From: Jonathan Best <Jonathan.Best@arun.gov.uk>
Sent: 21 May 2025 16:17
To: Planning.Responses <Planning.Responses@arun.gov.uk>
Cc: Hannah Kersley <Hannah.Kersley@arun.gov.uk>
Subject: P/43/25/PL

Land to the west of Inglenook Hotel 255 Pagham Road Nyetimber, PO21 3QB.

I have reviewed this application with regards to ecology and Biodiversity Net Gain.

Inglenook
Appendix 7 - tree protection plan - phase 2

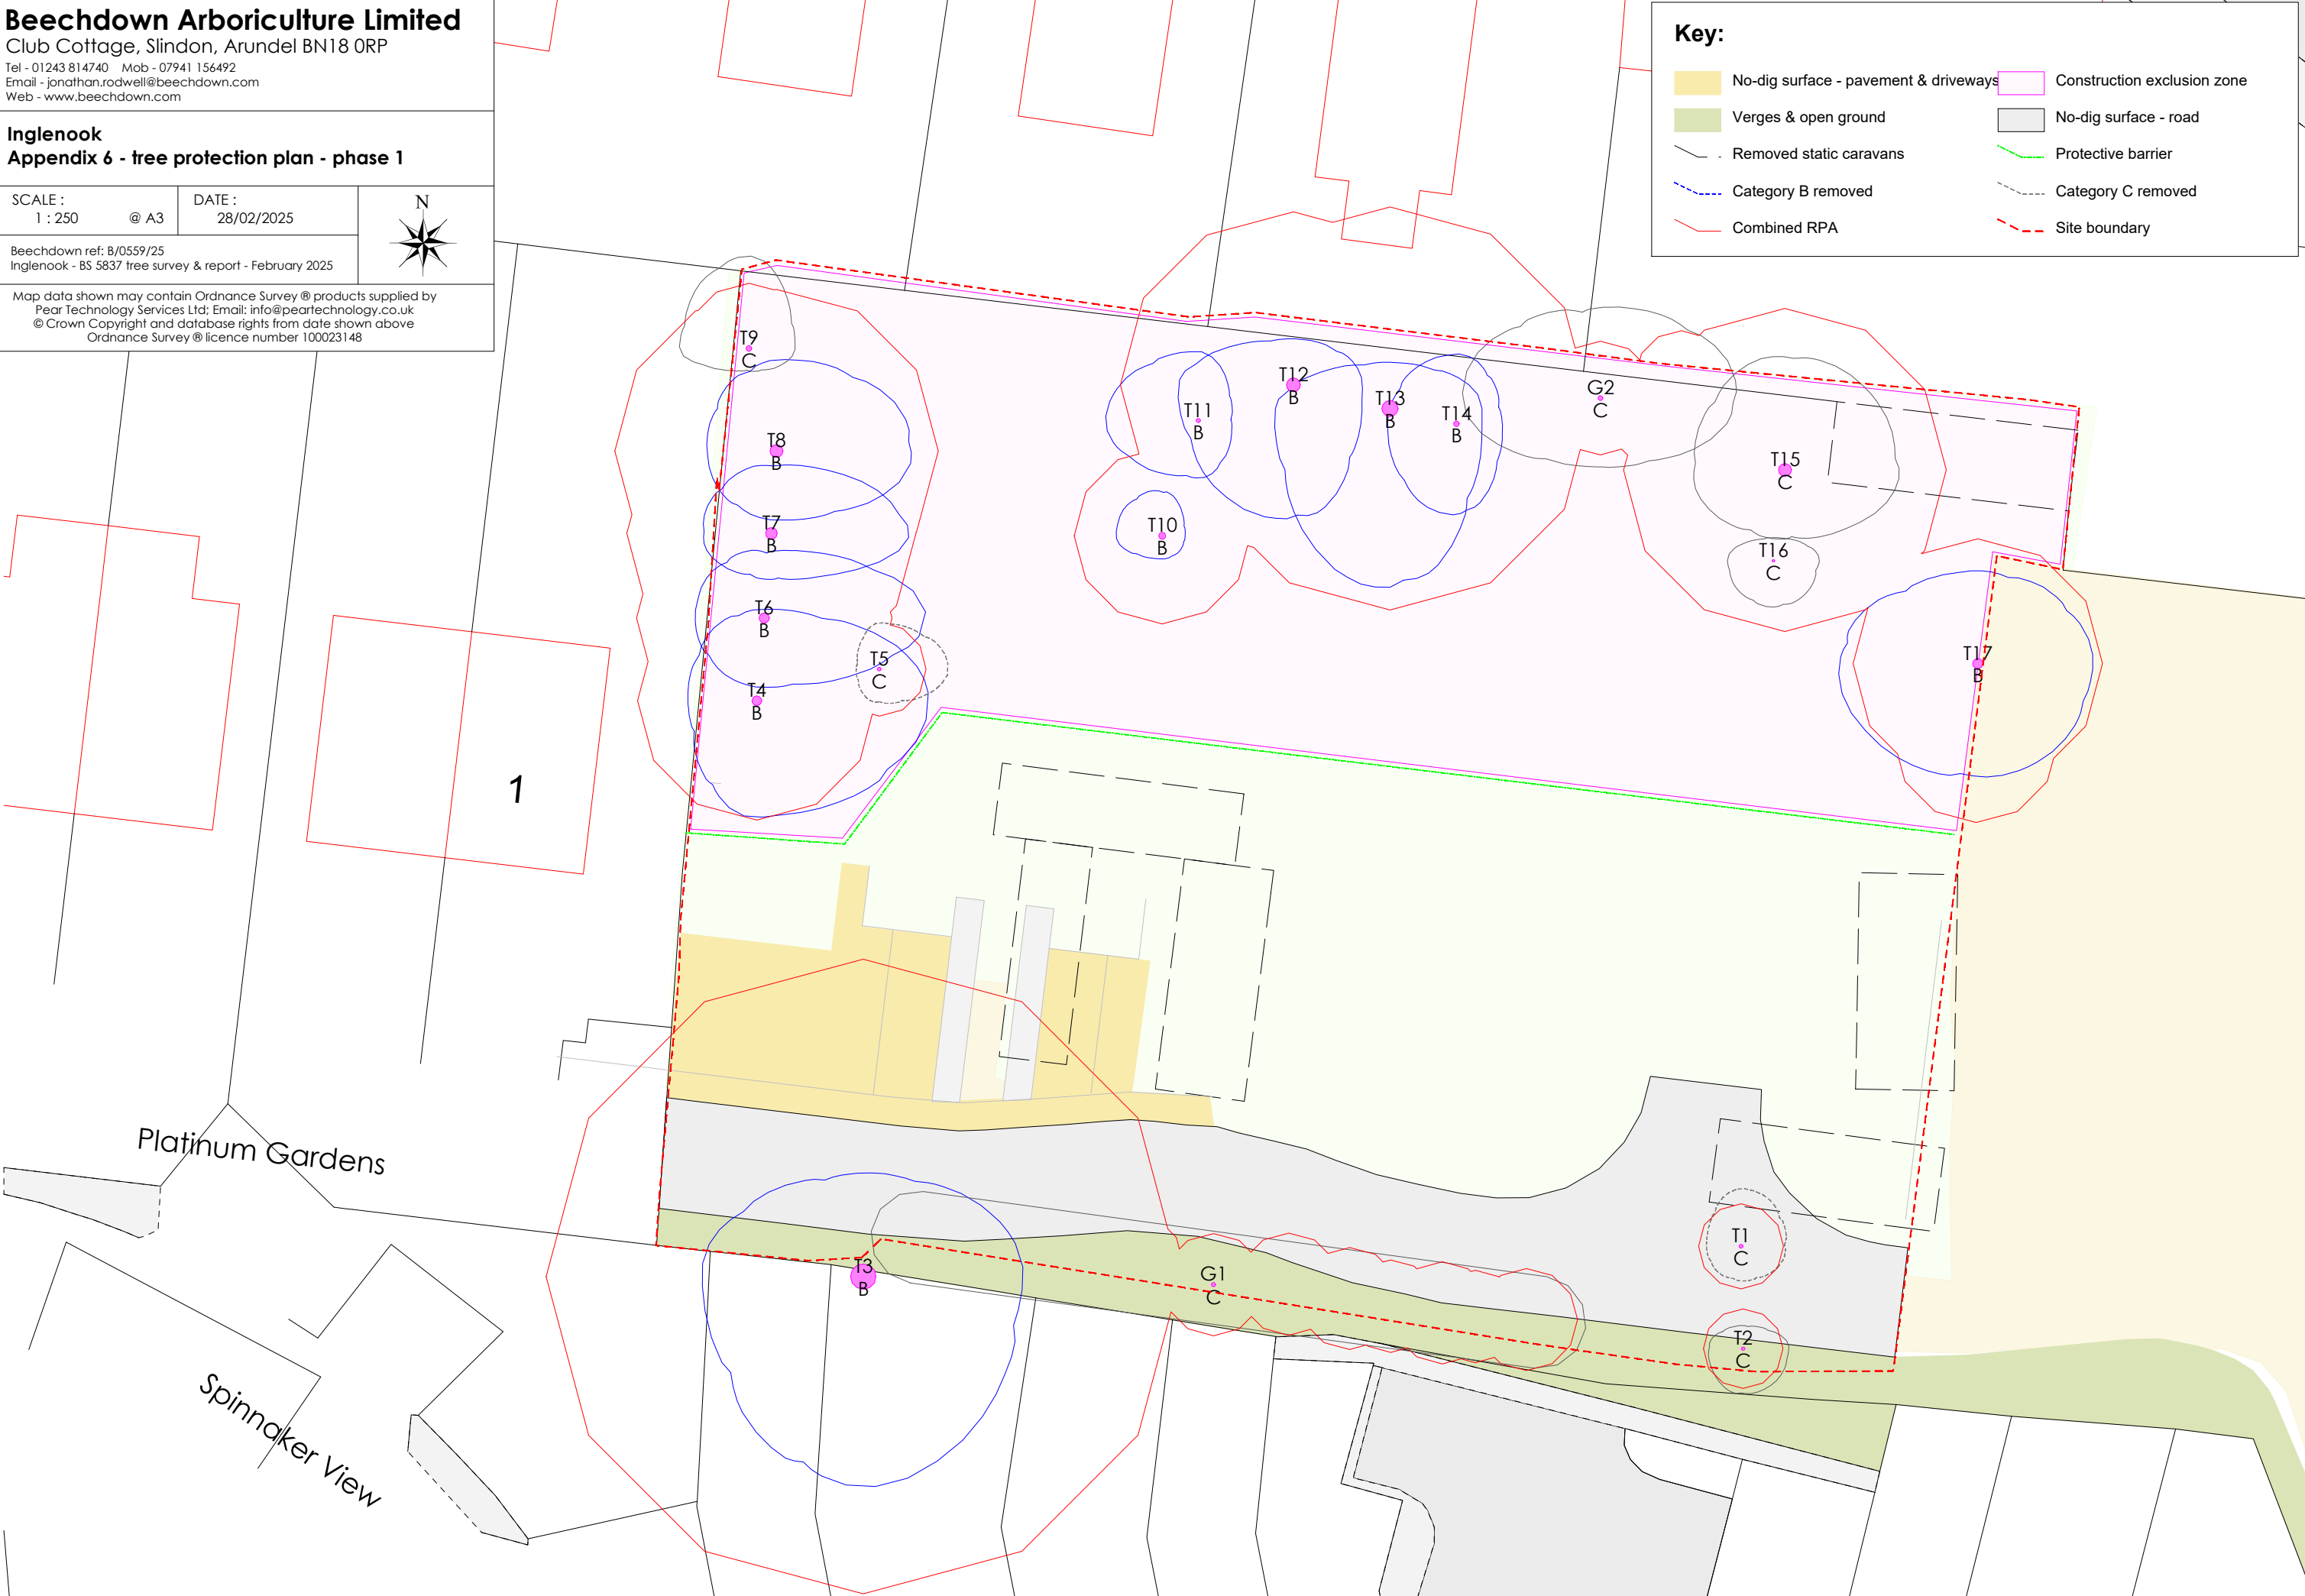
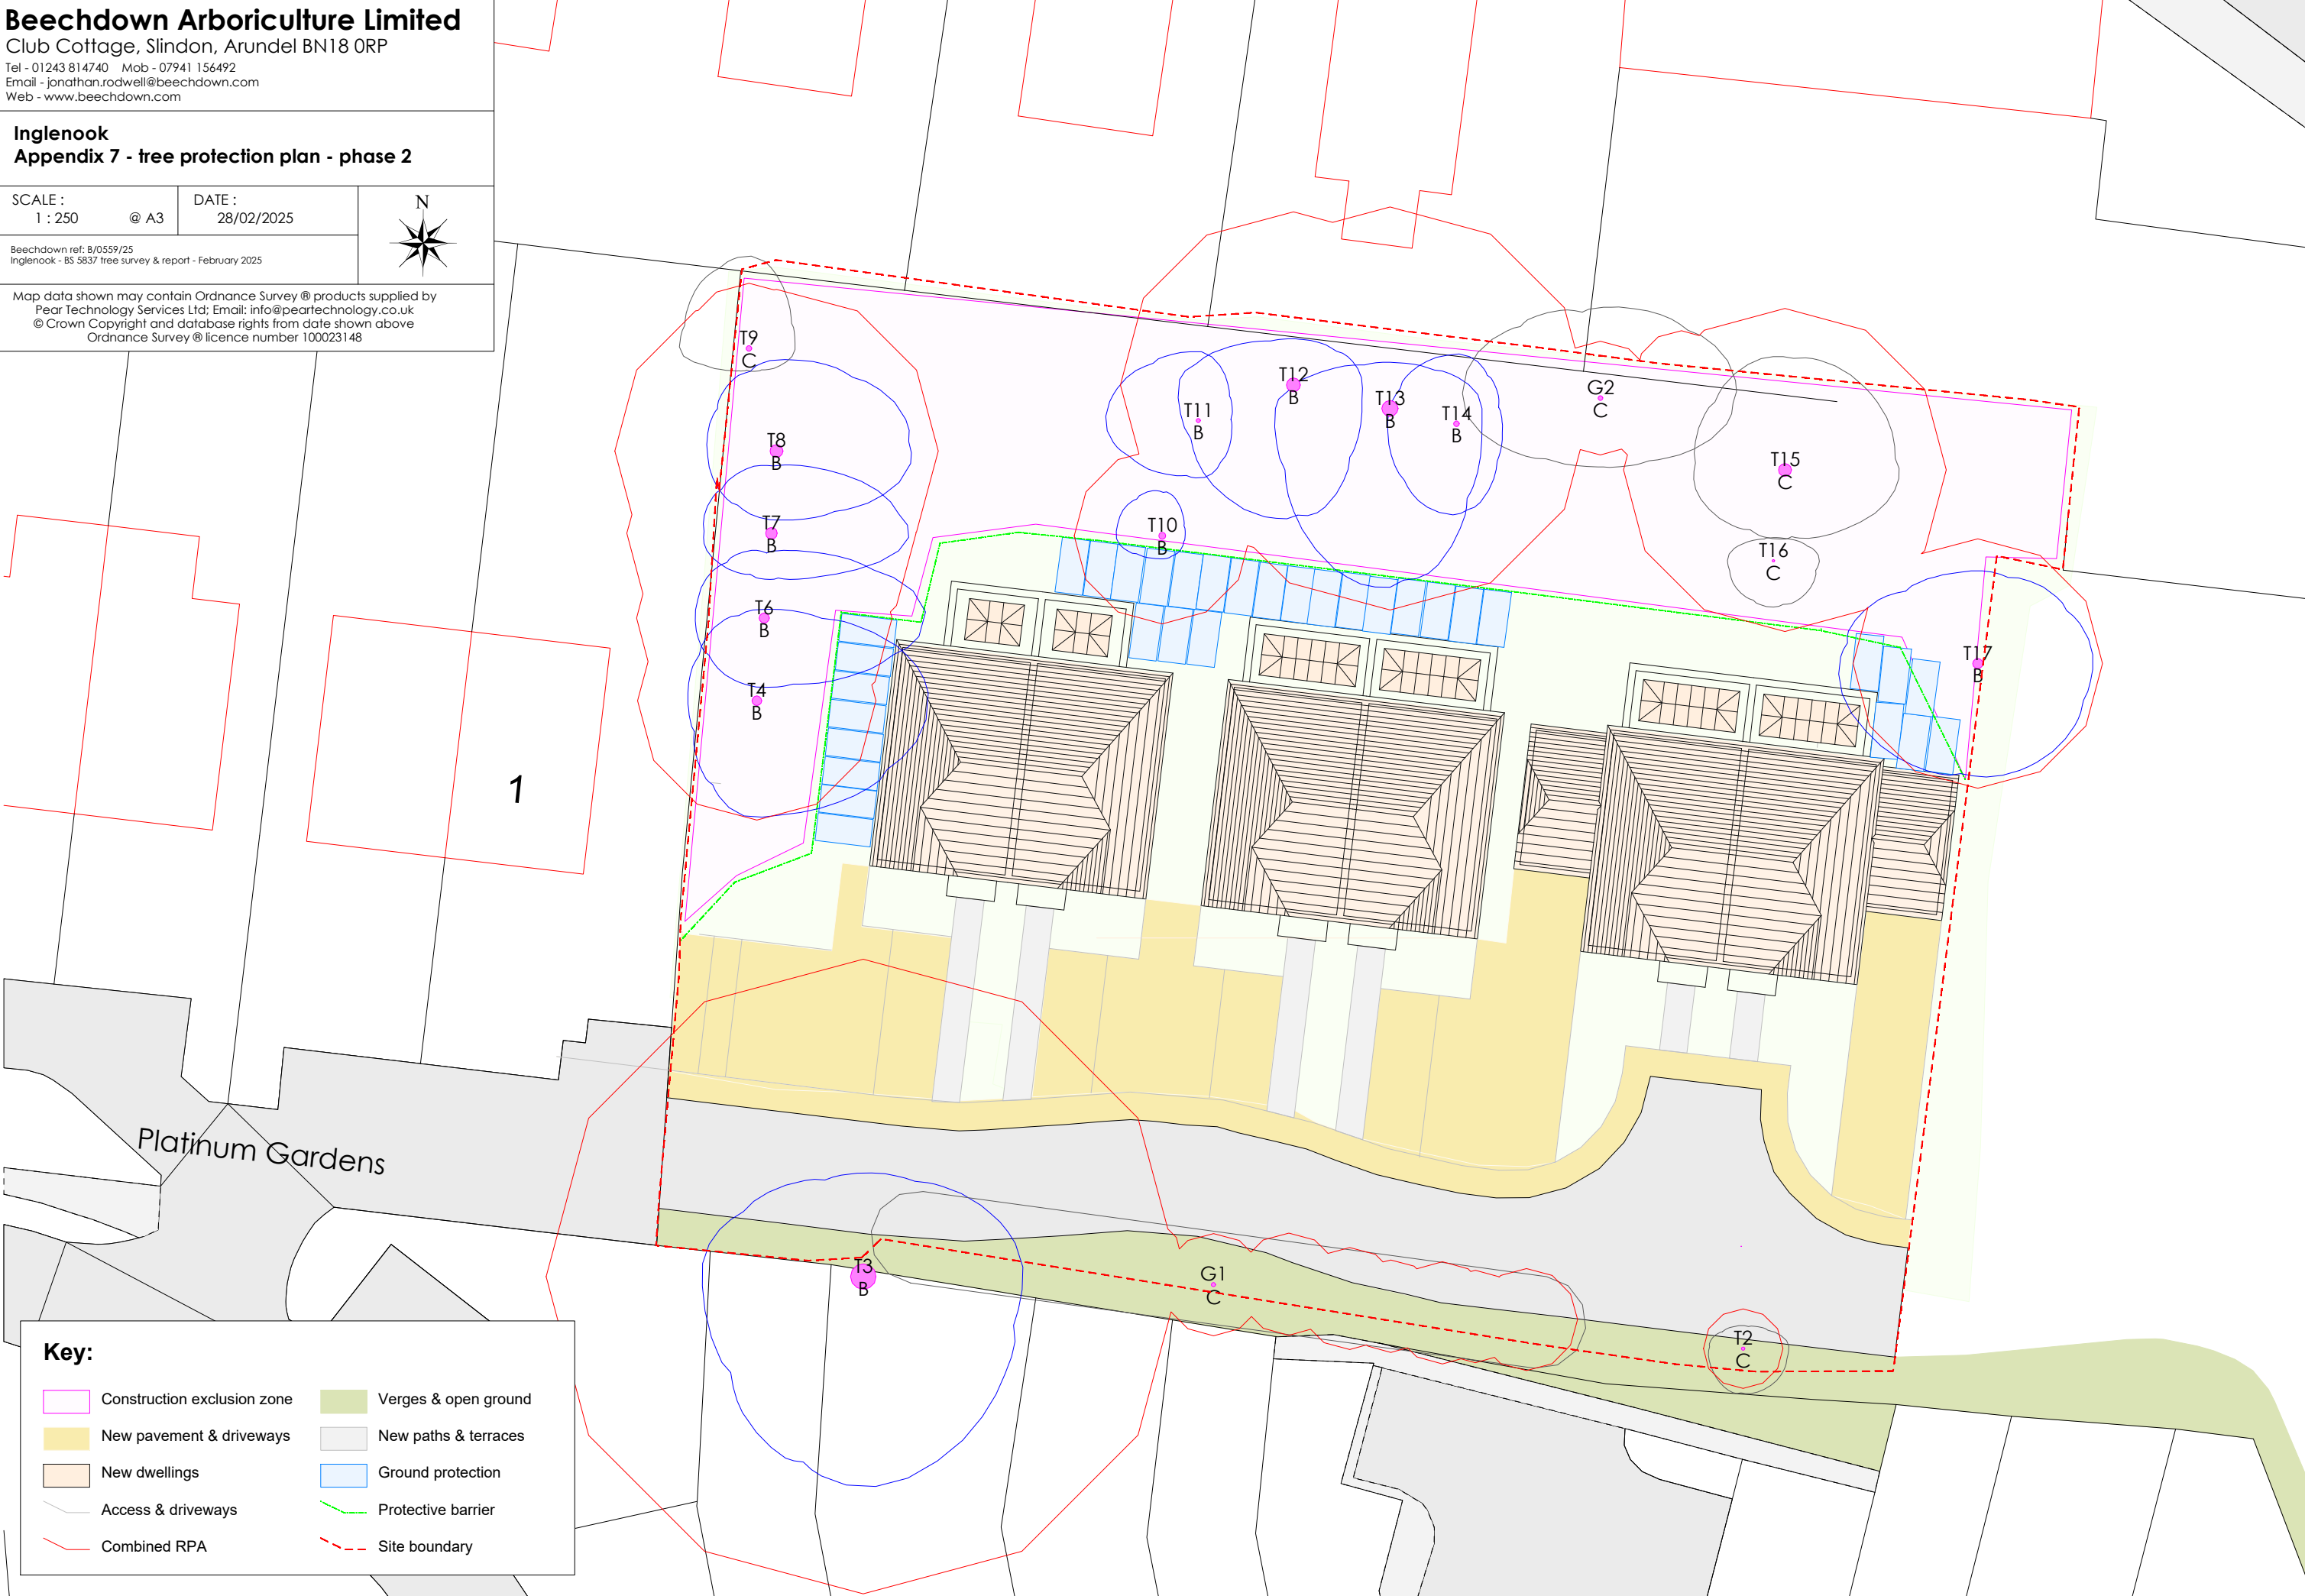
The BNG Metric has missing data tabs and also appears to have discrepancies regarding tree data as the Tree Survey Report records 10 trees with a girth greater than 300mm. This would give a habitat unit value of 0.33. Two of the medium trees (T4 and T6) are scheduled for removal and both may have a TPO on them. This has not been included in the Metric as all the trees are noted as retained. Clarification on the trees is required.
